TS/D3/07/915/MRN (VF)

25 October 2007

**TOWN AND COUNTRY PLANNING ACT 1990
PROPOSED REDEVELOPMENT OF SITE WITH GROUND FLOOR RETAIL
UNIT AND 2NO DUPLEX APARTMENTS
FRIENDSHIP GARAGE WHALLEY ROAD READ
FOR S STANSFIELD**

Site Plan

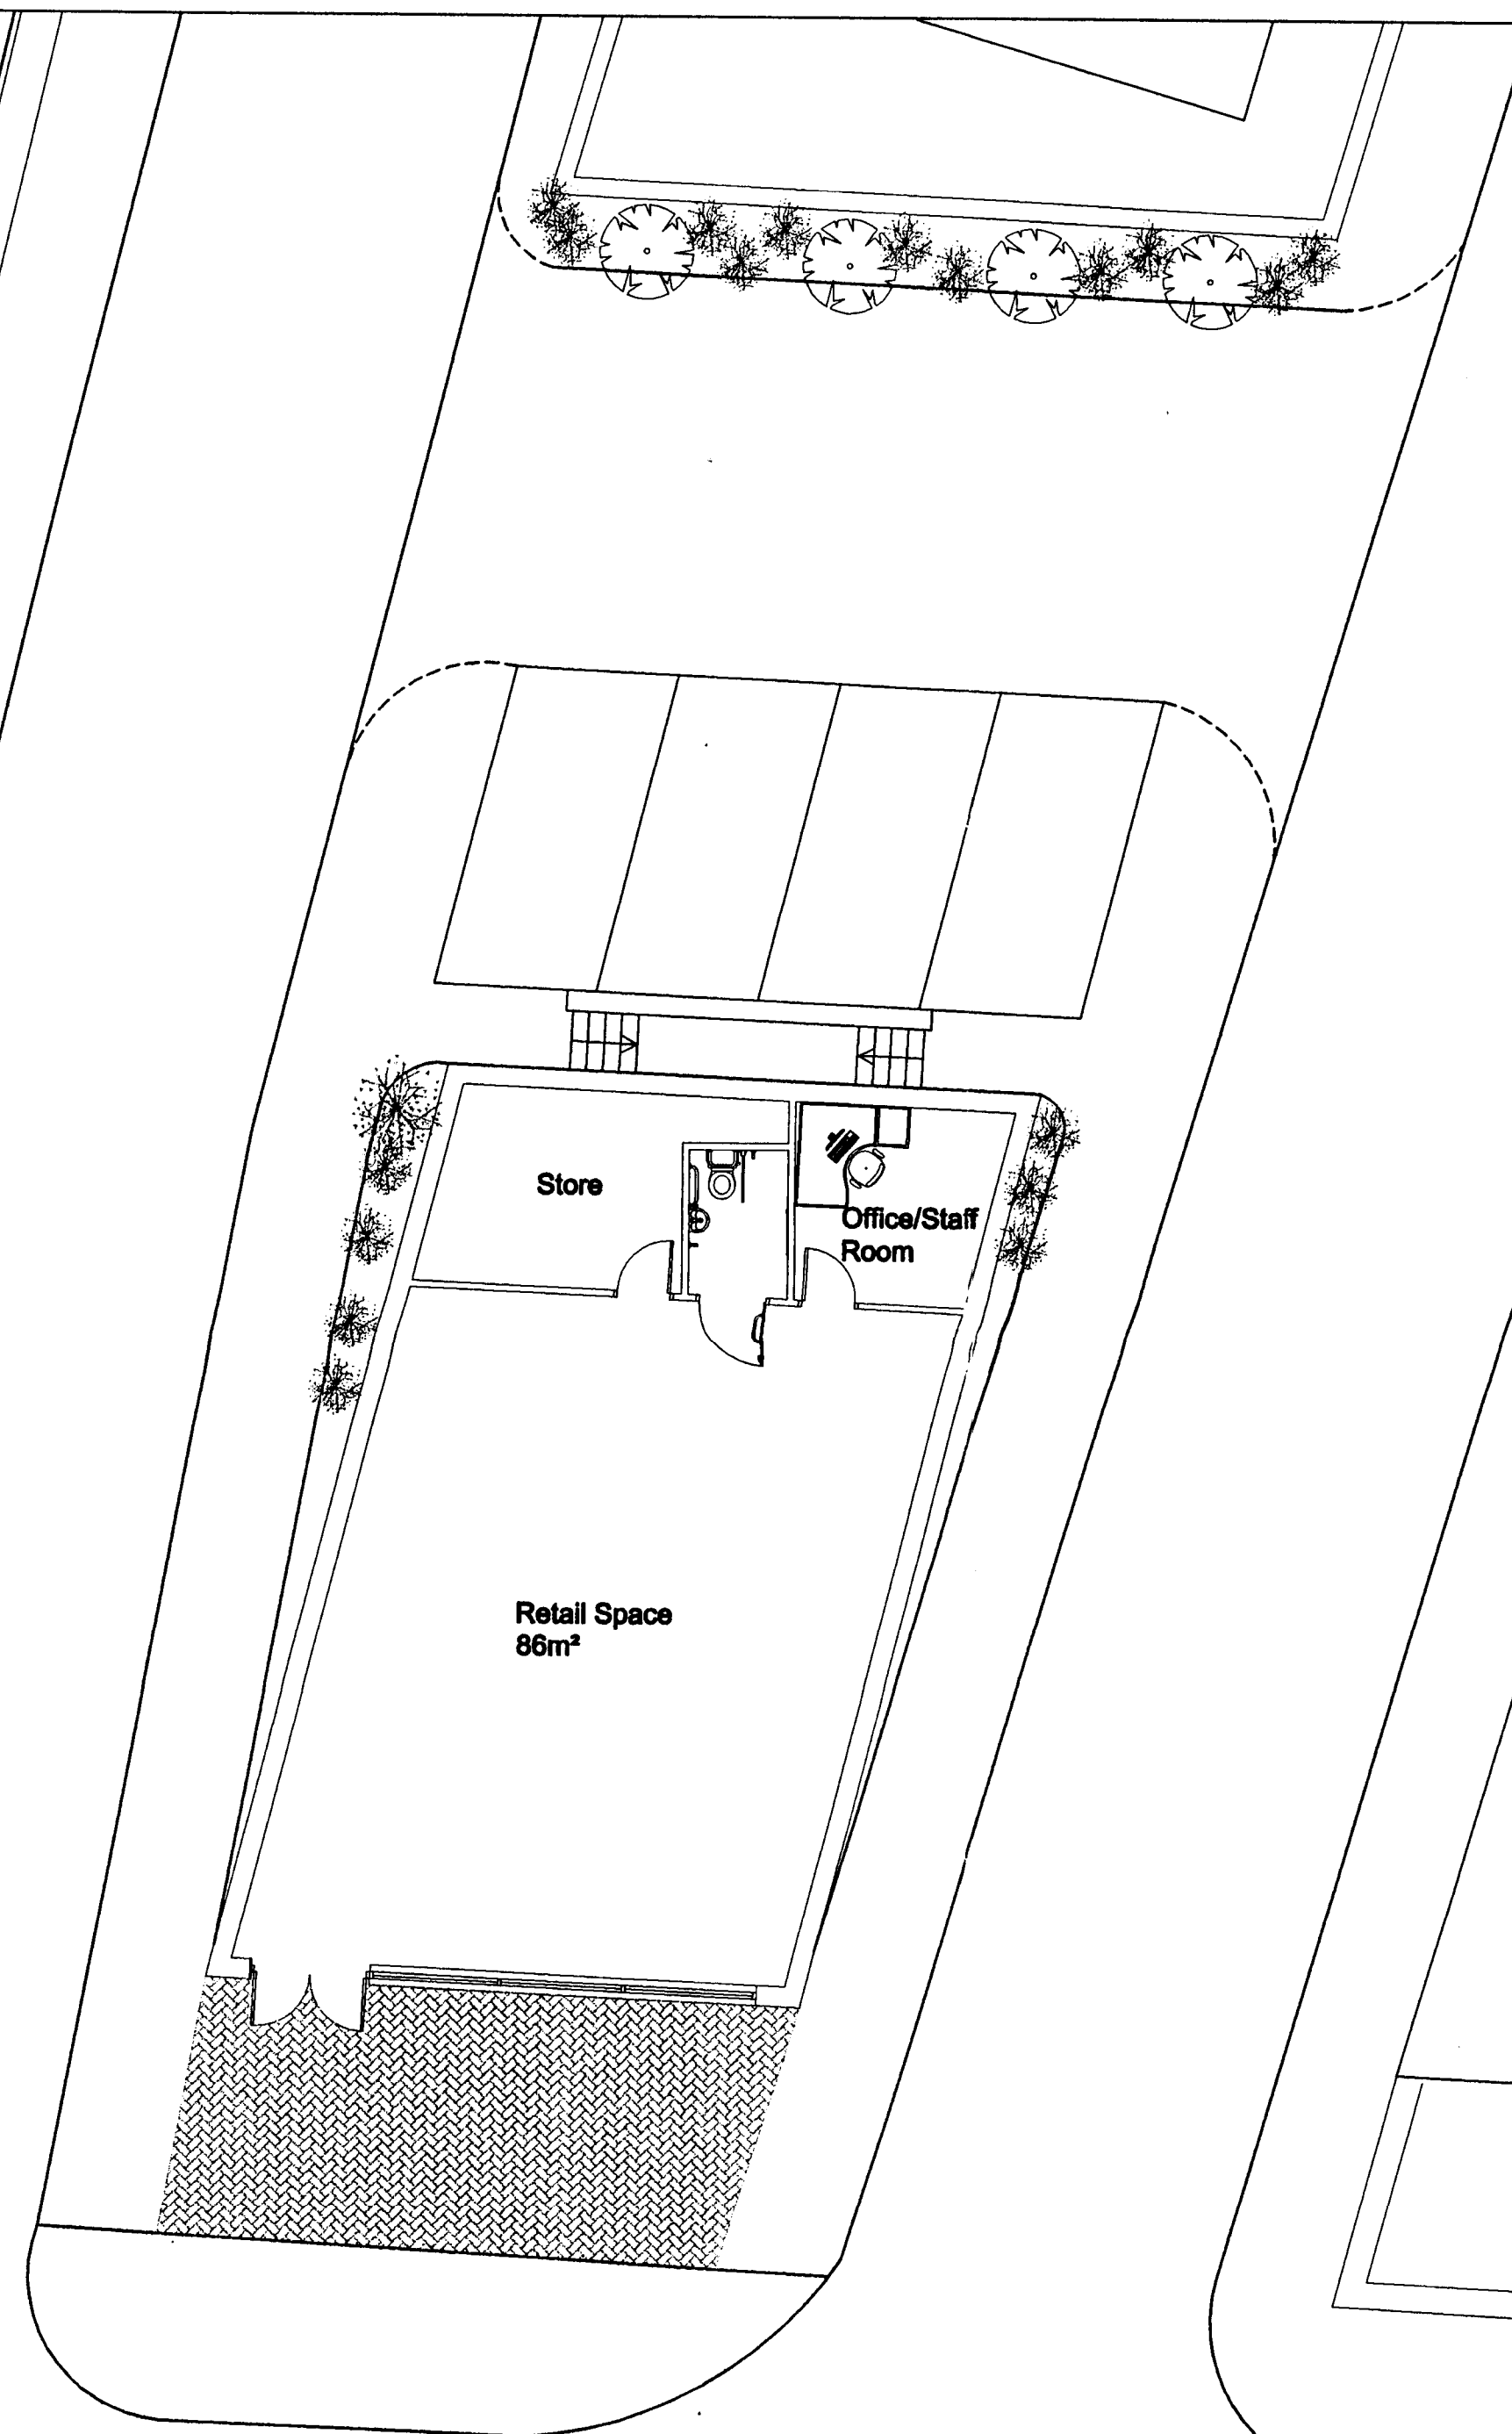
It is unclear from the site plan and the accompanying information how the area to the front of the development is to operate. This is presently a garage forecourt, designed to accommodate the through movement of vehicles and is clearly intended to be the focus of pedestrian activity to the retail space. There is no indication from the application drawings that this area is to be closed to vehicular movements.

Therefore, I will require a Condition to secure the physical and permanent closure of the existing access from George Street and Church Street, with the reinstatement of the footway and kerbing in accordance with the Lancashire County Council Specification for Construction of Estate Roads. This is to secure safe pedestrian access and limit the number of access points to, and to maintain the proper construction of the highway.
